Rezoning Transportation Analysis

Petition Number: 2021-174

Revision Log:

Date	Description
11-22-21	First Review (TM)
12-17-21	Second Review (WB)
01-06-22	Third Review (WB)
01-25-22	Fourth Review (WB)

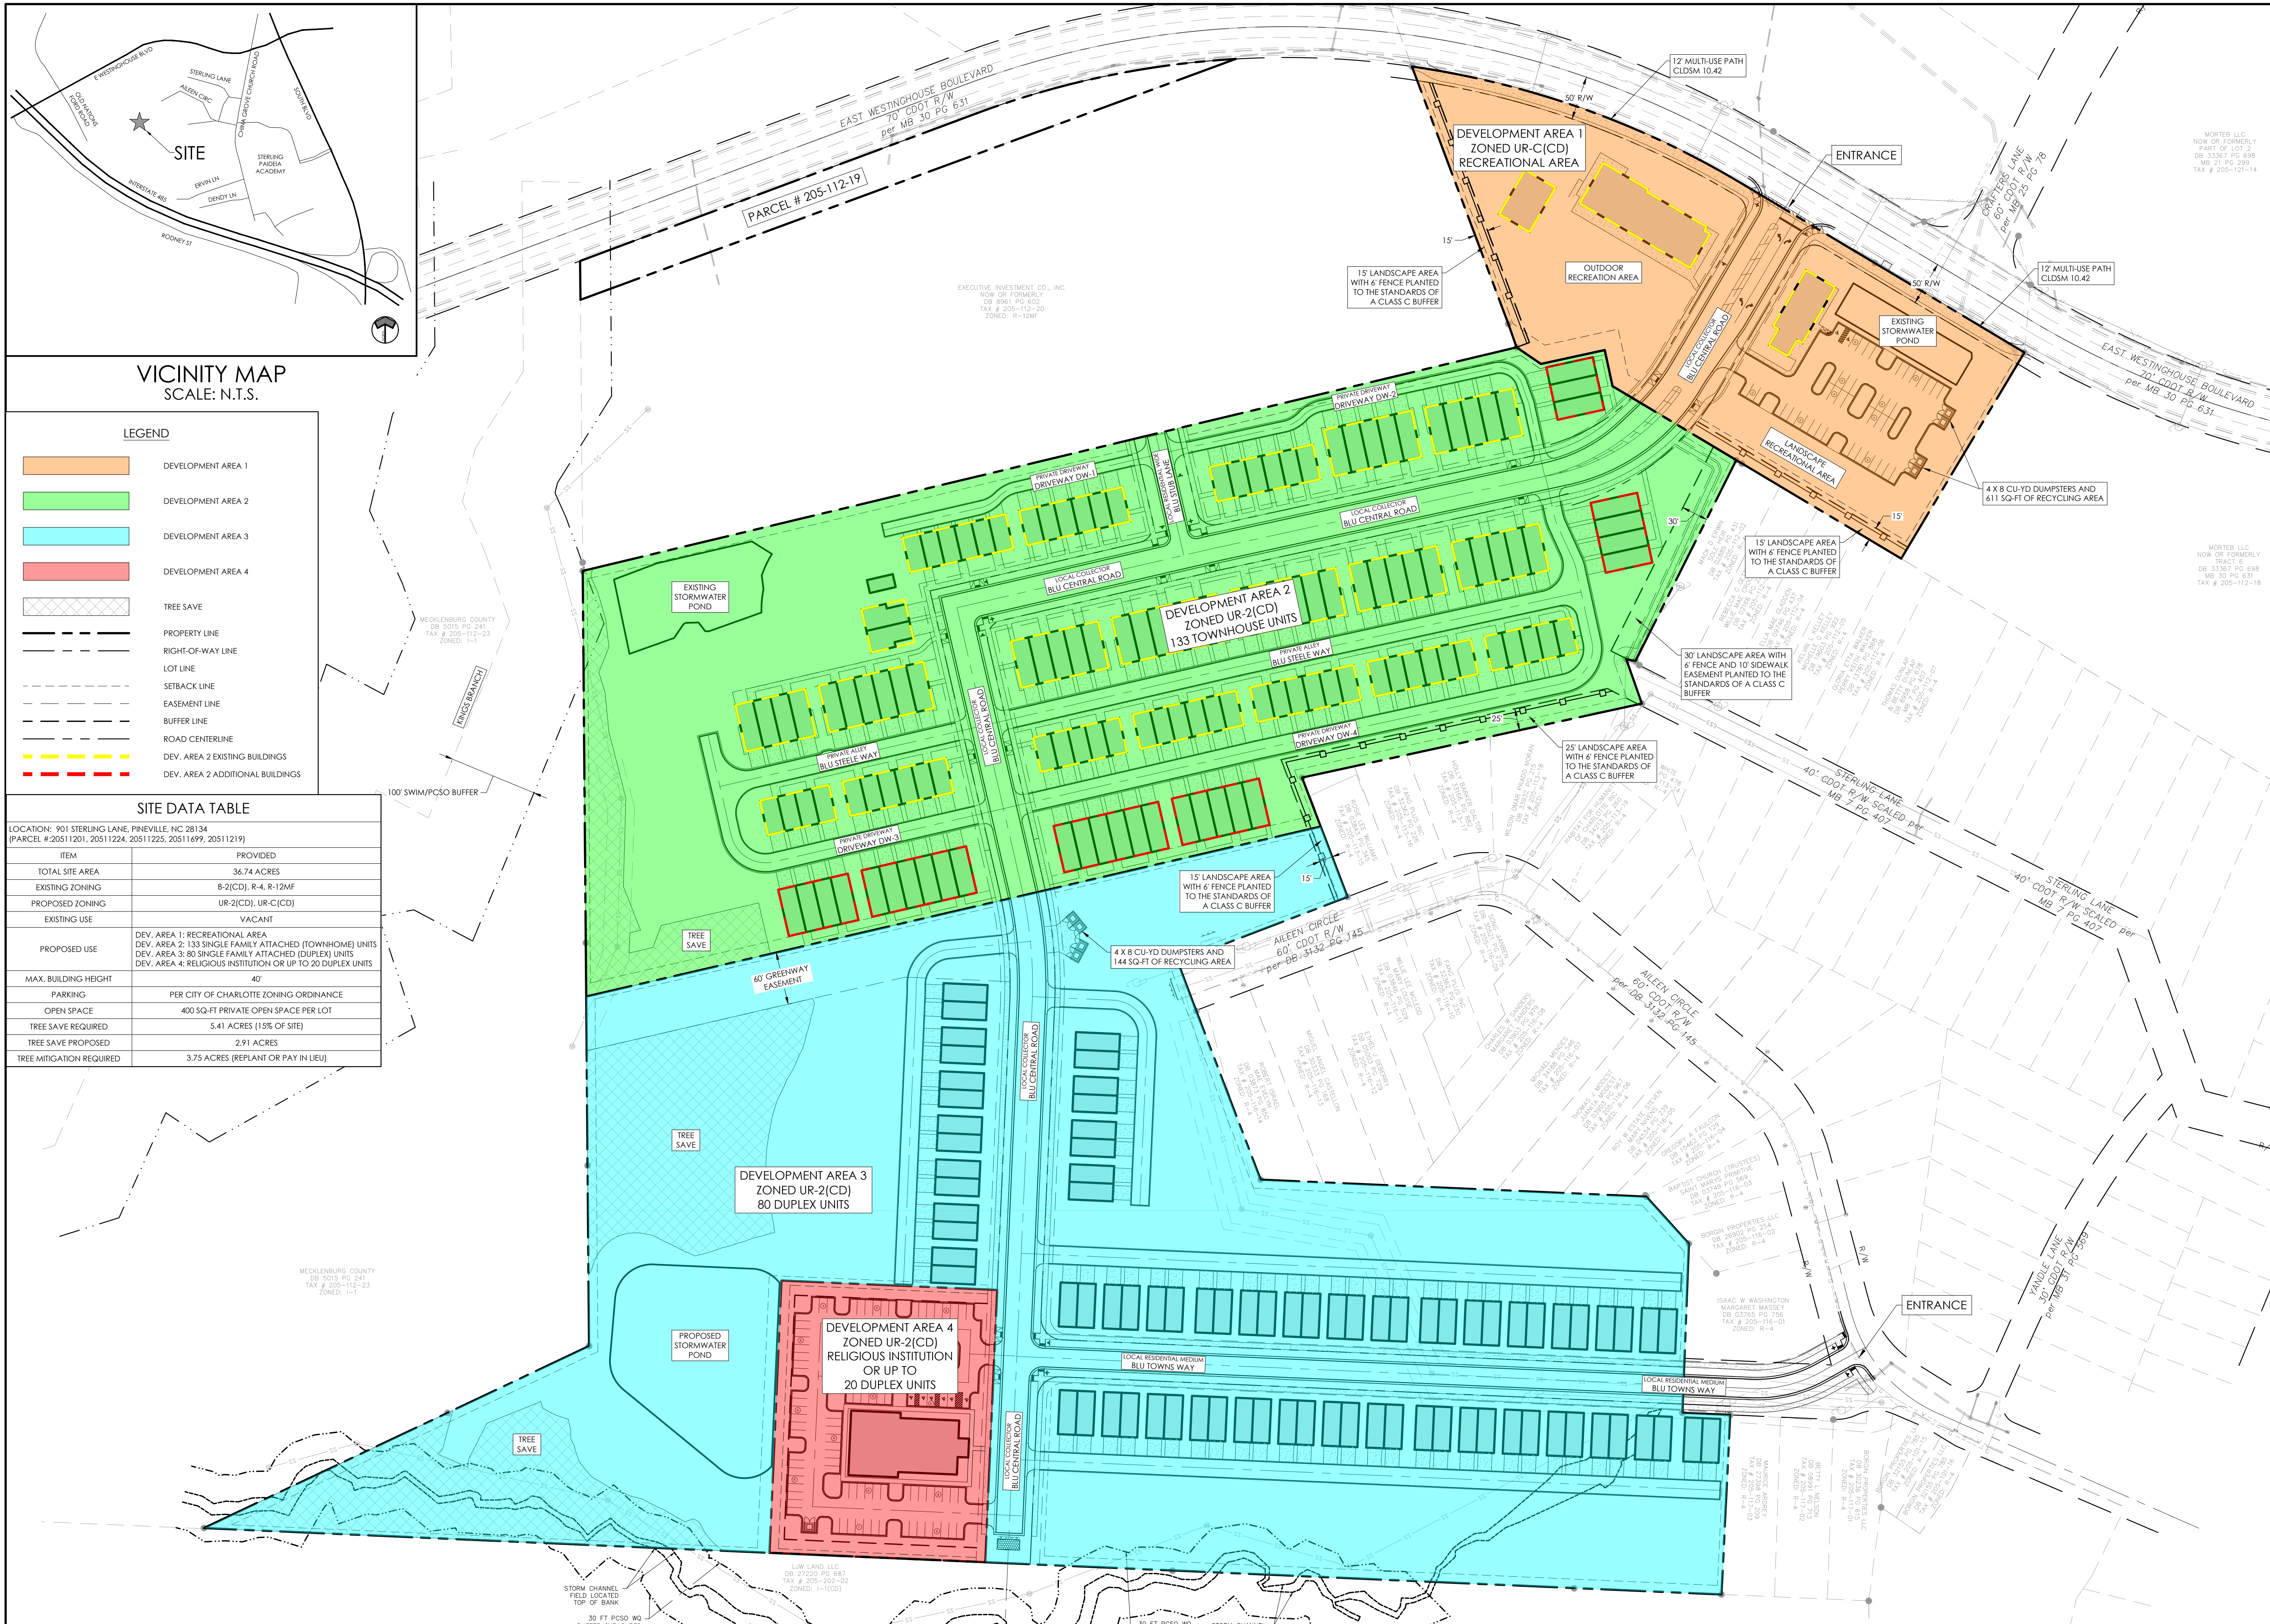
Curbline: The proposed zoning district has a setback measured from back of the future curbline.

- ~~**East Westinghouse Boulevard:** The future back of curb and gutter shall be installed at 33 feet from the existing street centerline. Revise site plan to show the future back of curb.~~

Label and dimension the existing and future curb and gutter from the centerline for each road on the site plan.
